Planning application: AB/148/17/PL

**Proposal: To provide 4 No. detached houses on existing semi natural woodland site. |
Wooded Land South West of Dalloway Road, Arundel**

The Trust has been made aware of further comments submitted by the applicants (dated 2 March 2018) to response to concerns about the loss of ancient woodland that the planned development would result in.

1515 SK 10

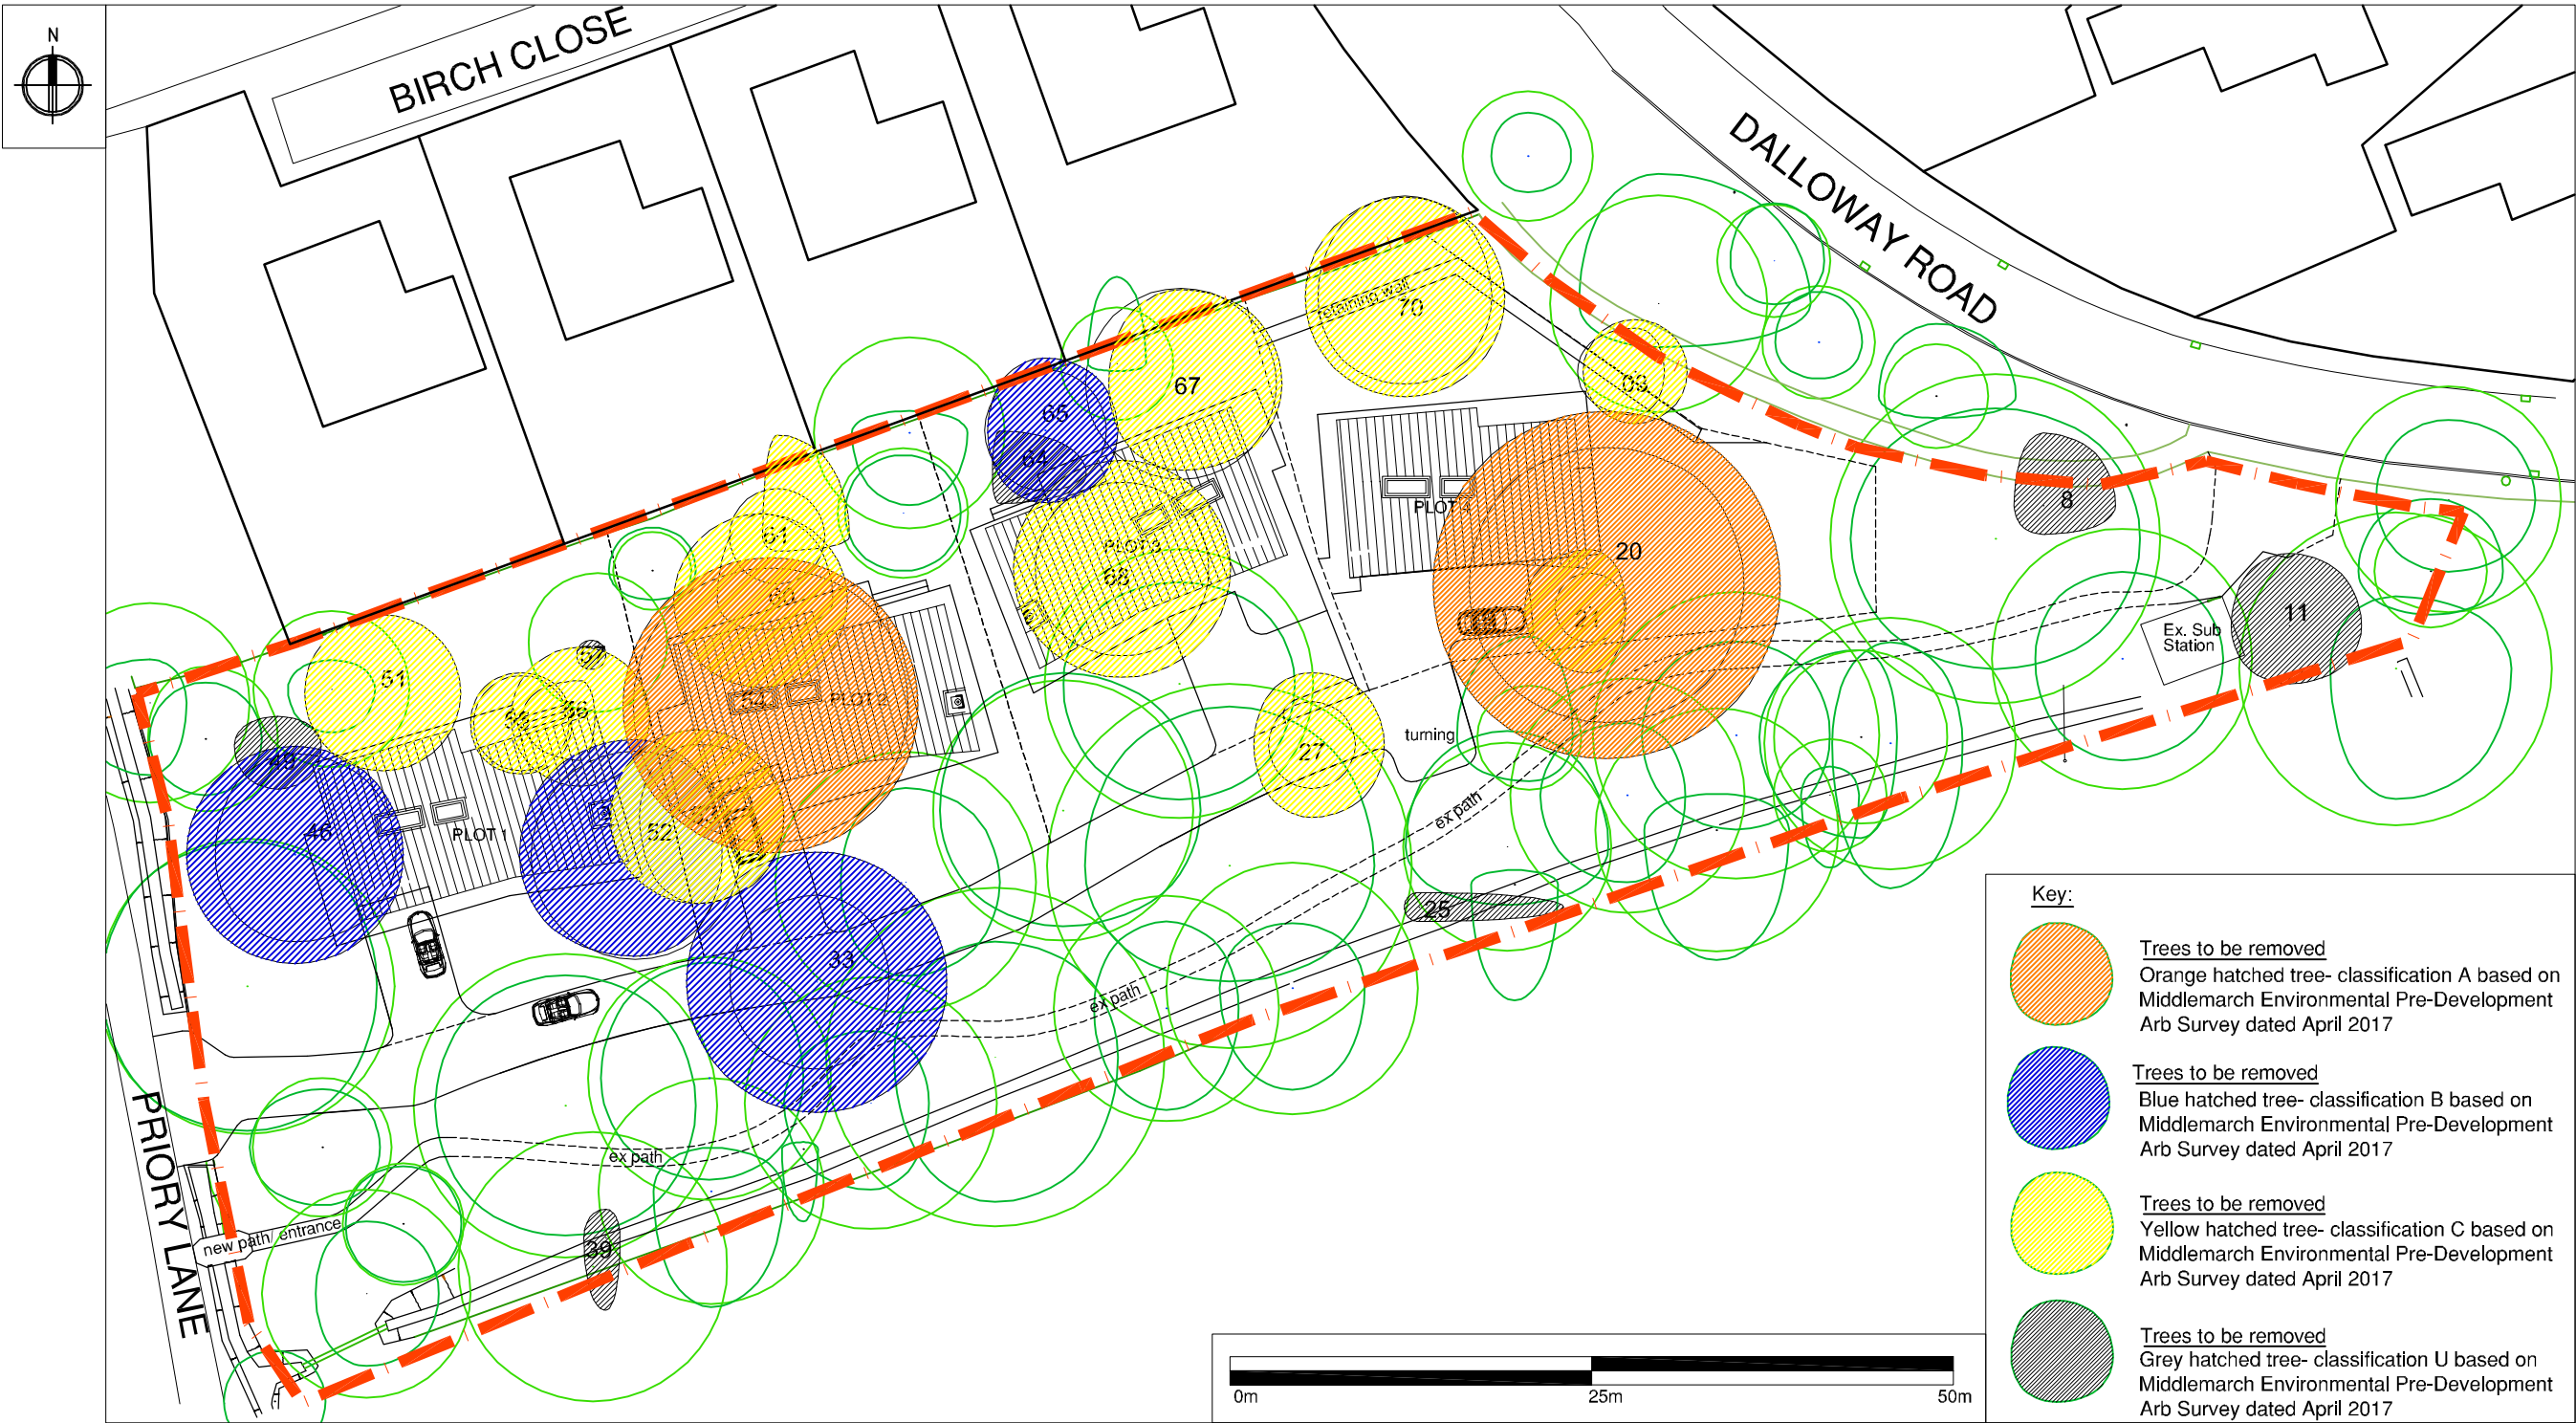
The applicant states that "the actual loss of open space is less than 10% of the site area and the dwellings are located and design in such a manor [sic] as to minimise the loss of mature trees". Any loss (10% or otherwise) of ancient woodland is wholly unacceptable. While mature trees can be retained in gardens the intensification of human activity will destroy all other ancient woodland features within the garden areas. While there may not be direct land

take across the whole of the ancient woodland, this development and the large increase in indirect impacts will effectively result in the entirety of this ancient woodland area being lost.

It is a misconception that ancient woodland is defined by mature trees. Ancient woodland typically has a varied age structure of trees on account of historical management and the processes of natural decline and regeneration. It is the ancient woodland soils that provide the foundation for ancient woodland species to flourish. Therefore, the siting of the dwellings, along with the driveways and gardens will result in the destruction of this ancient woodland.

The Woodland Trust **strongly objects** to the proposed development. The applicant has demonstrated a fundamental misunderstanding of ancient woodland. Allowing a development proposing the destruction of ancient woodland would set a dangerous precedent and would fly in the face of policy designed to protect these important and irreplaceable habitats. As stated in our previous response, these houses do not have to be located in ancient woodland and must be moved outside of and away from ancient woodland.
